Re: CNSW COE – External Lighting Strategy Report – SSD-10354 Response to Submissions

Please find below the response to submissions regarding the external lighting strategy for the Cricket NSW Centre of Excellence.

Item 65 – Lighting

## Appendix A    Lighting strategy site plan

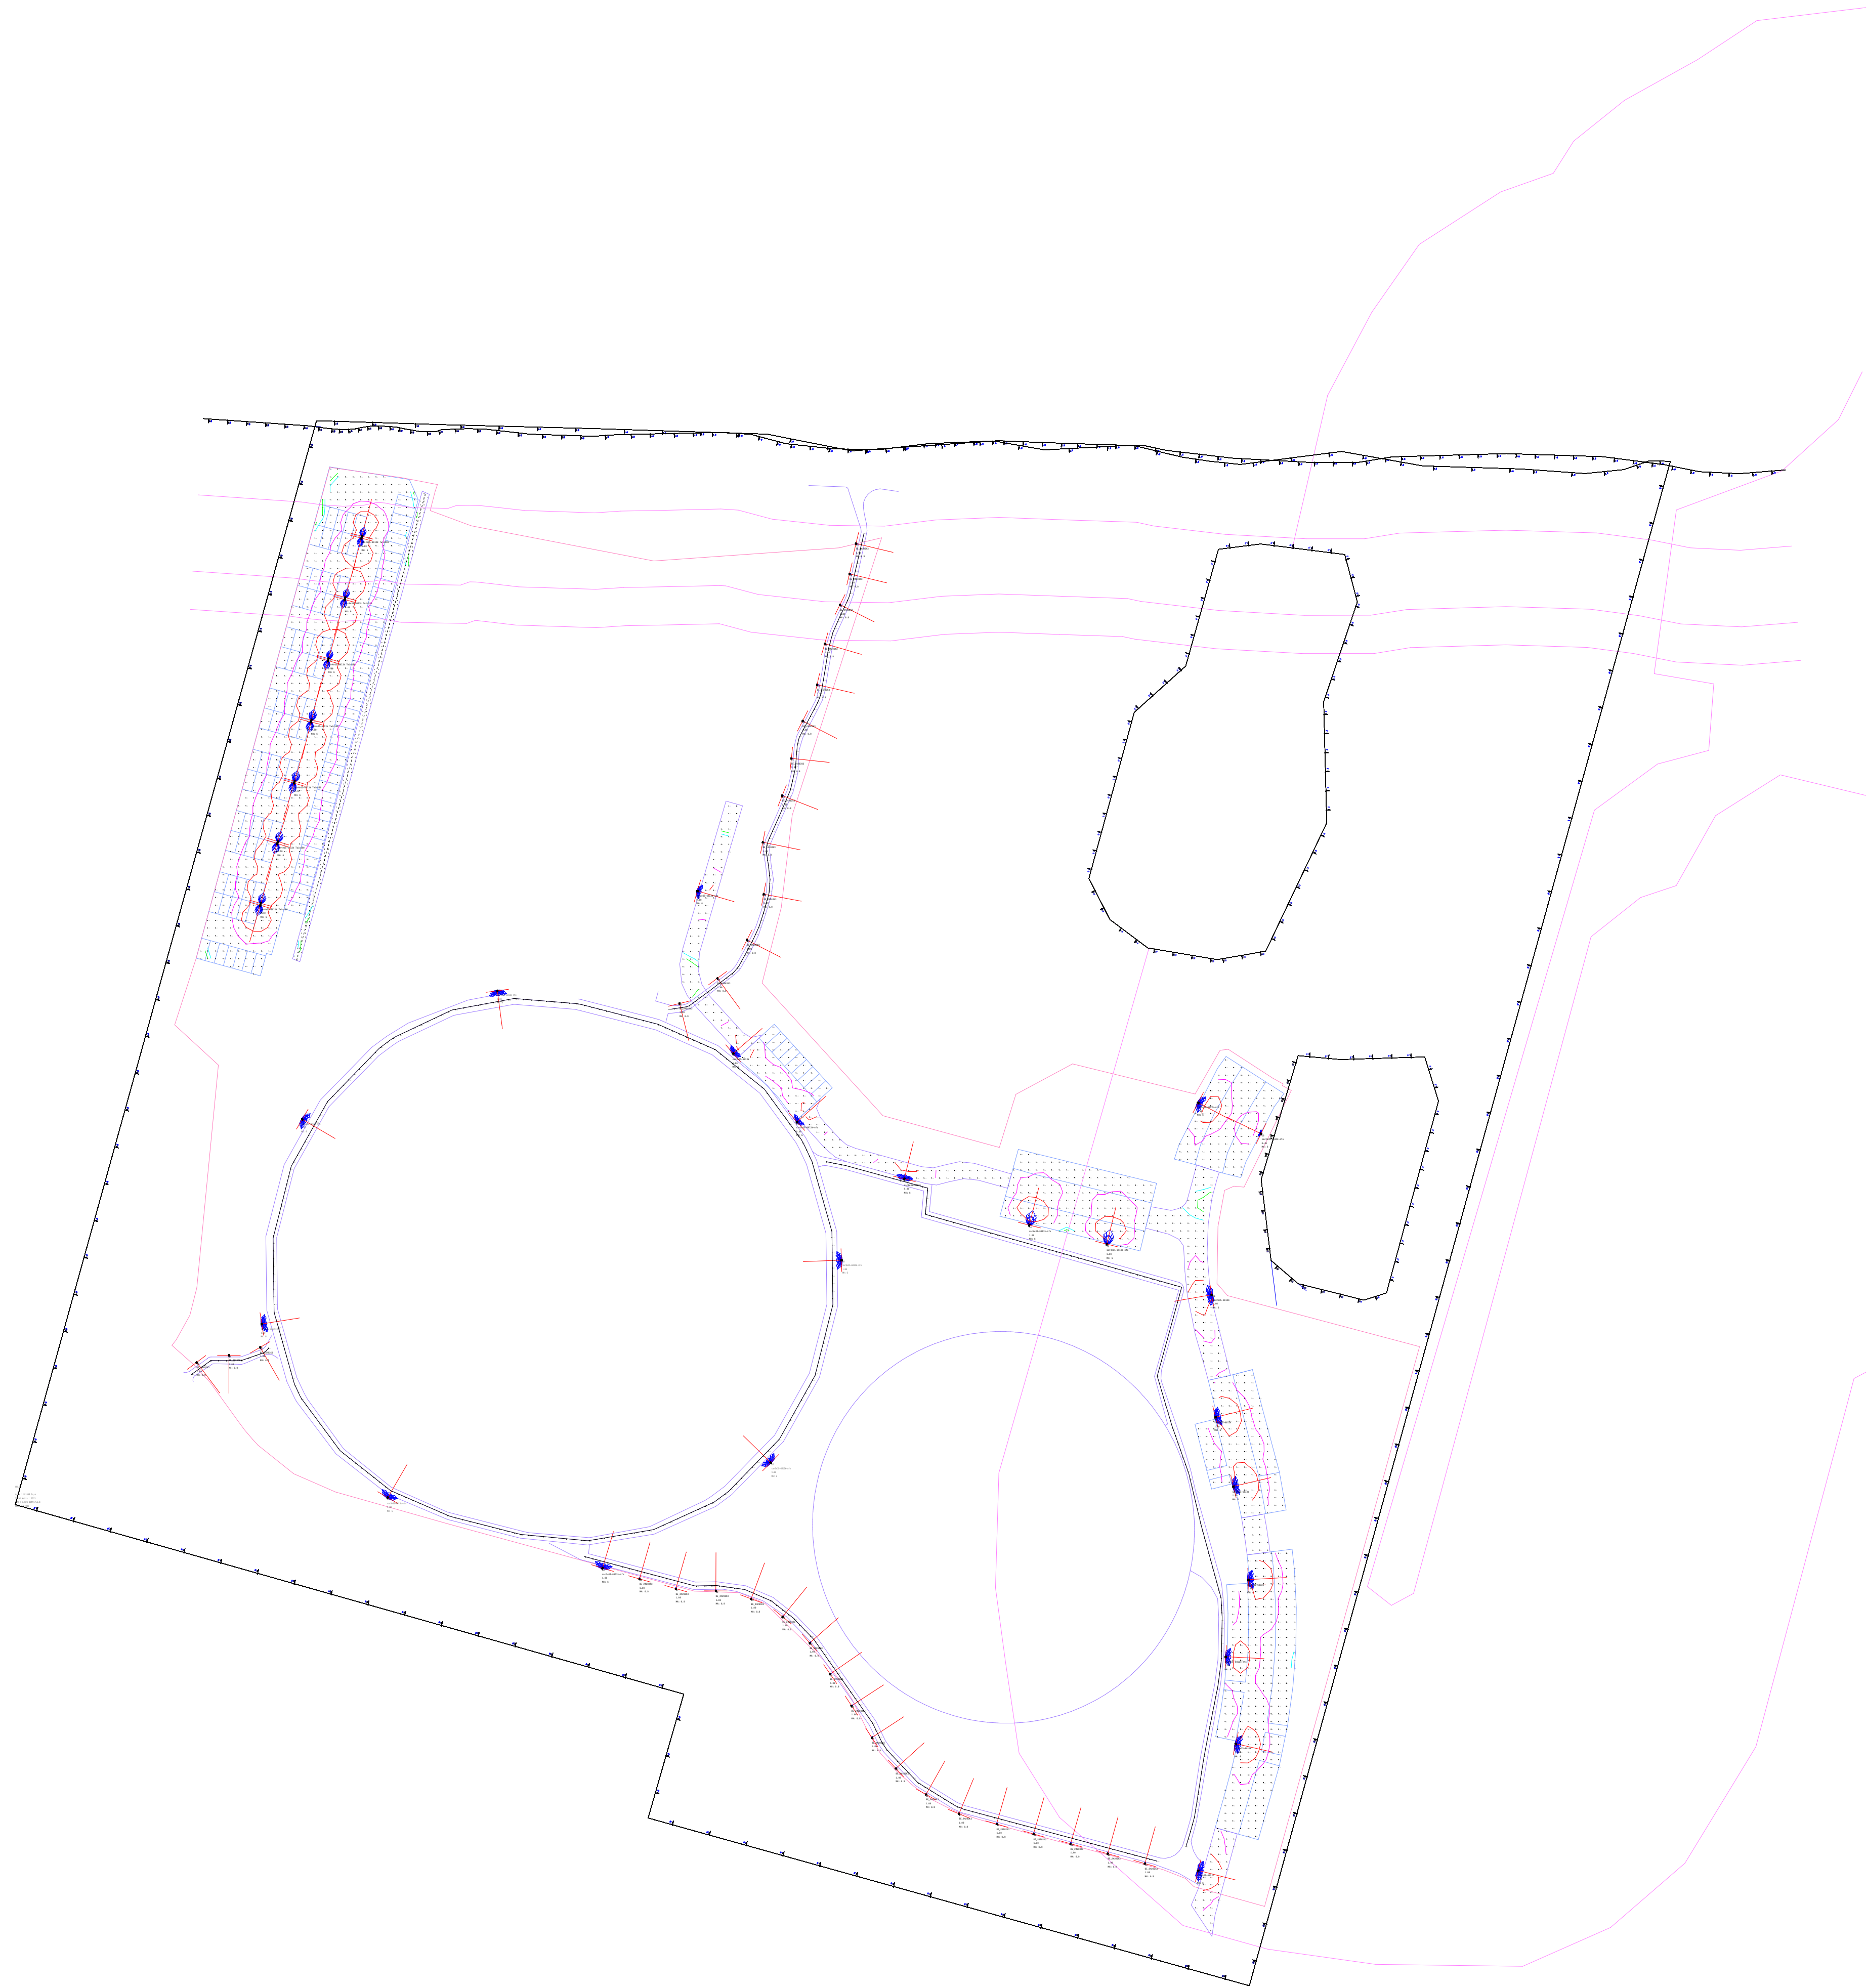
- *Lighting controls should be managed judiciously to limit hours of operation to suit the circumstances of the site; ensure a lack of lighting to deter visitation to inappropriate areas and to support visitation to areas where after-dark use is desirable or invited.*

- *External lighting of the fields must not extend past 10pm. External security and way-finding lighting must be designed and operated in accordance with the lighting management principles of the SOPA Parklands Plan of Management.*

Refer report Section 9.3 (Switching and control), Sections 9.4-9.12 for reduced lighting levels (or switched off), and drawing External Lighting Strategy – Concept Design – Curfew.

Note the proposed cricket facility is within the 50m and 100m buffer of the river and artificial wetlands, however, spill has been minimised through placement of luminaires, reduced curfew lighting levels and by the switching strategy – eg. turning off carpark lights and pathway lights near the river and artificial wetlands – refer drawing: External lighting strategy, Concept Design - Curfew.

External lighting on the main oval is proposed around the perimeter pathway only. Curfew lighting strategy is detailed in Section 9.4 and drawing: External Lighting Strategy, Concept Design – Curfew. This includes dimming fittings around the oval from P3 to a P4 category as discussed in Section 9.3, turning off pathway lighting where not required during curfew, dimming and turning off carpark lighting where not required during curfew and dimming maintenance road access luminaires during curfew. This meets requirements for lighting minimisation as per the PPOM and as discussed in Item 65 above.

## Appendix B      Concept site lighting design

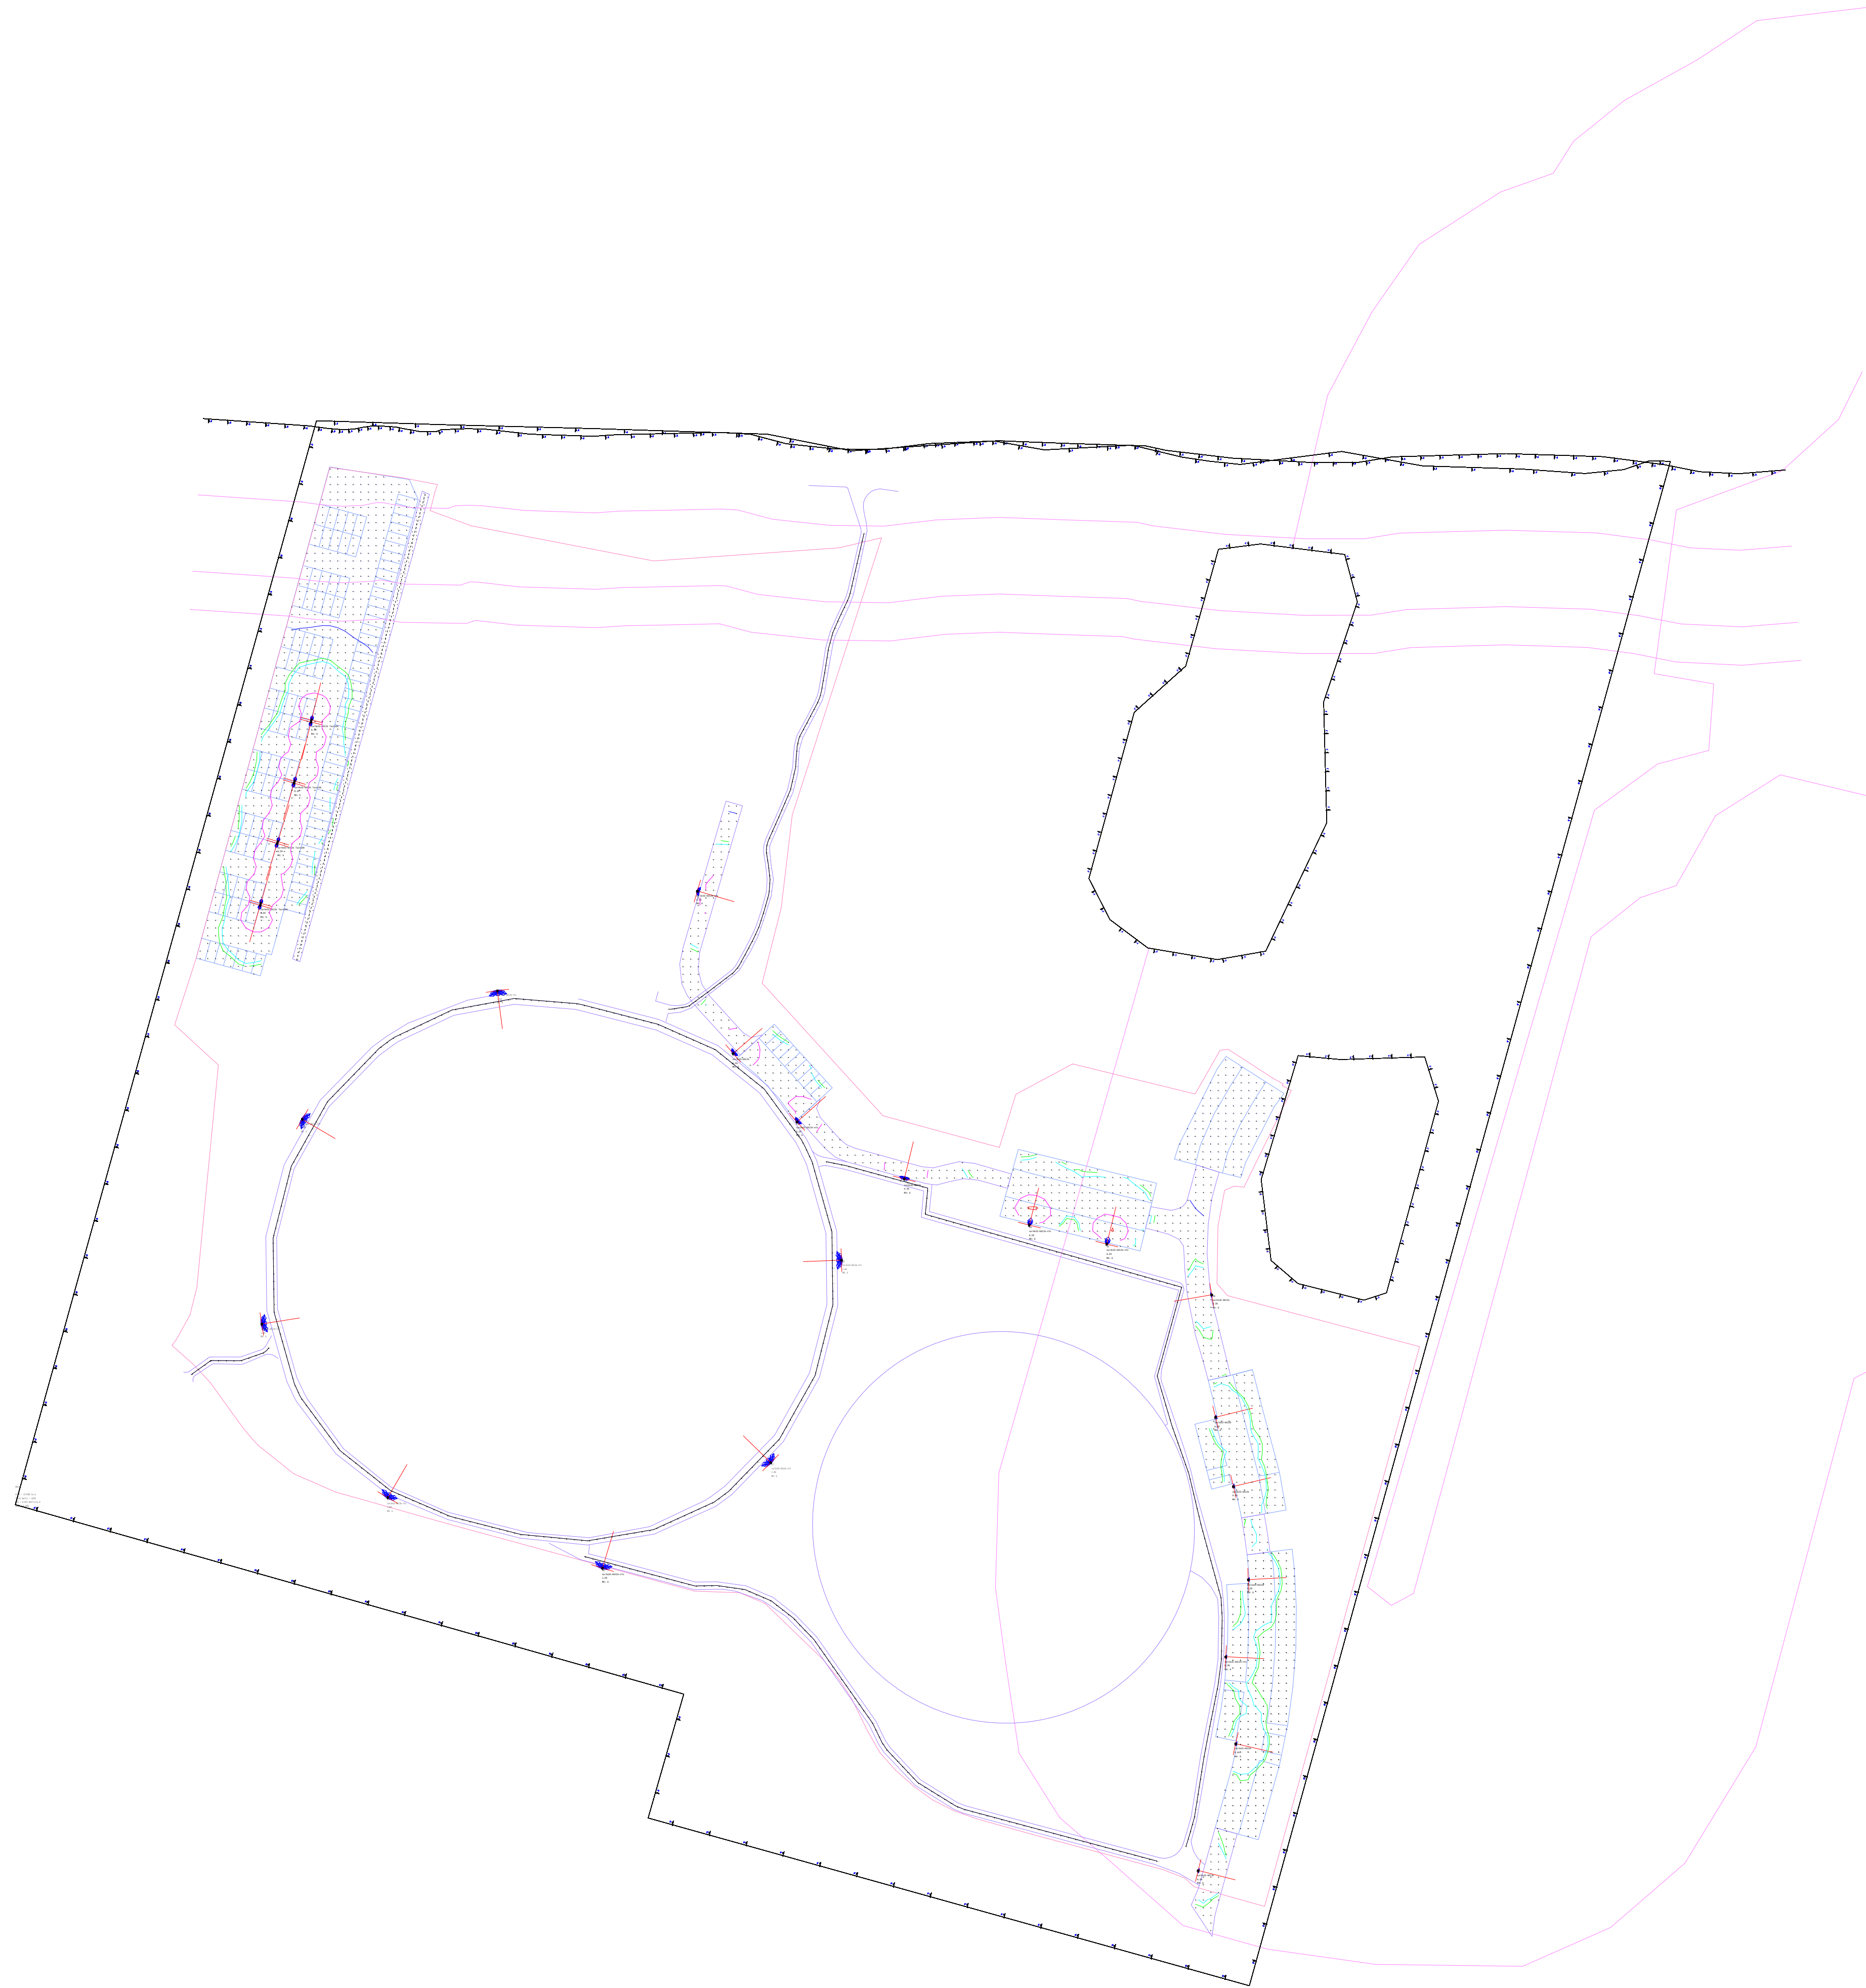
- *Lighting should be non-intrusive to neighbouring residents or Parkland users and be considerate of the cumulative effects with other lighting - within and outside the Parklands.*

- *The upward light output ratio must be less than 5% relative to their installed mounting orientation; and*

Preliminary light spill assessment has been conducted to comply with AS 4282 (refer Section 8), with spill lighting calculations provided as Appendix B.

Glare shields have been incorporated into the design where possible – refer Appendix B luminaire type XXX-nfo (neighbour friendly optic).

Preliminary calculation UWLR is 0% for both curfew and non-curfew. Refer Appendix B.
